# HAL OWEN & ASSOCIATES, INC.

13 March 2018

Reference: Report Addendum to Comprehensive Soil Investigation and Septic System Design  
JPF Properties LLC Property; PIN 1537-17-7973

Figure 2. Septic System Layout

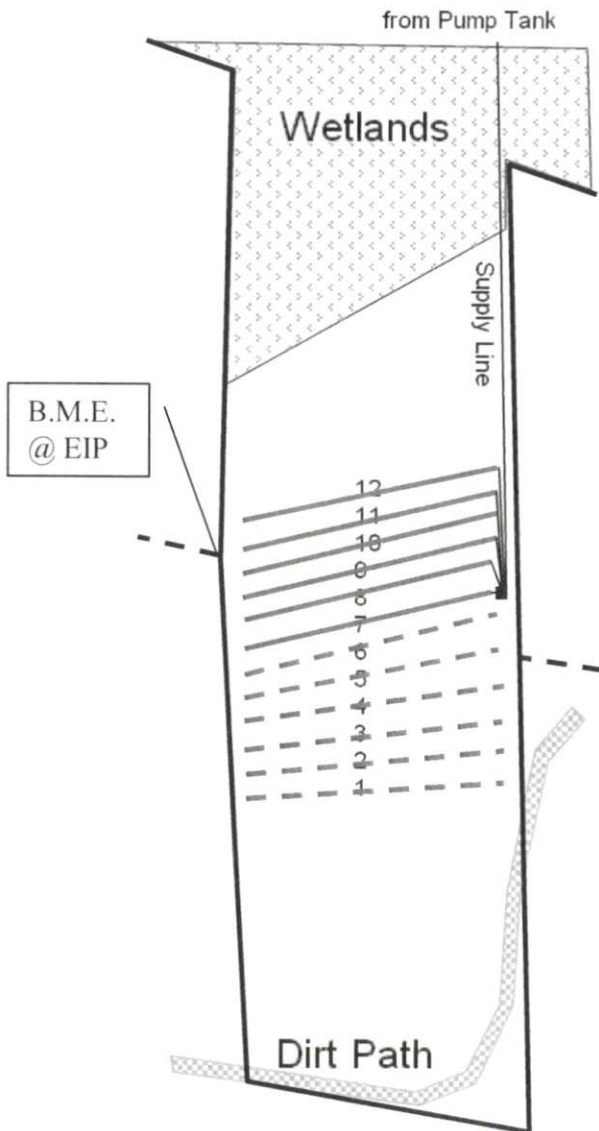
Due to the presence of the road easement, the available space for the septic drainfield is reduced slightly. The setback for septic drainlines from a property line is typically ten feet. However, the presence of the road easement effectively increases the setback along this property line to 15 feet because drainlines may not be installed in the easement.

An easy solution would be to reduce the length of each line of the system by five feet. The initial drainfield was designed as six conventional drainlines each 141 feet long. Reducing each line by five feet would result in six conventional drainlines each 136 feet. In this scenario, the long term application rate would back calculate to 0.42 gal/day/sqft. Soil observations made at the site support this loading rate.

Another solution would be to convert the system from conventional gravel drainlines to accepted status drainlines, such as EZflow. Use of accepted status drainlines in place of conventional lines allows the required amount of linear drainline to be reduced by up to 25%. Given a daily design flow of the facility of 1016 gallons and a loading rate of 0.4 gal/day/sqft, the minimum amount of accepted status drainline is calculated as 635 feet. This could be evenly distributed into six lines with each drainline 106 feet.

Another option would be to add an additional drainline to each system. Additional usable soil area is available above the proposed repair area which is not currently utilized in the design. Each system (initial and repair) is currently designed with six lines, but could be redesigned with seven conventional drainlines each 121 feet long.
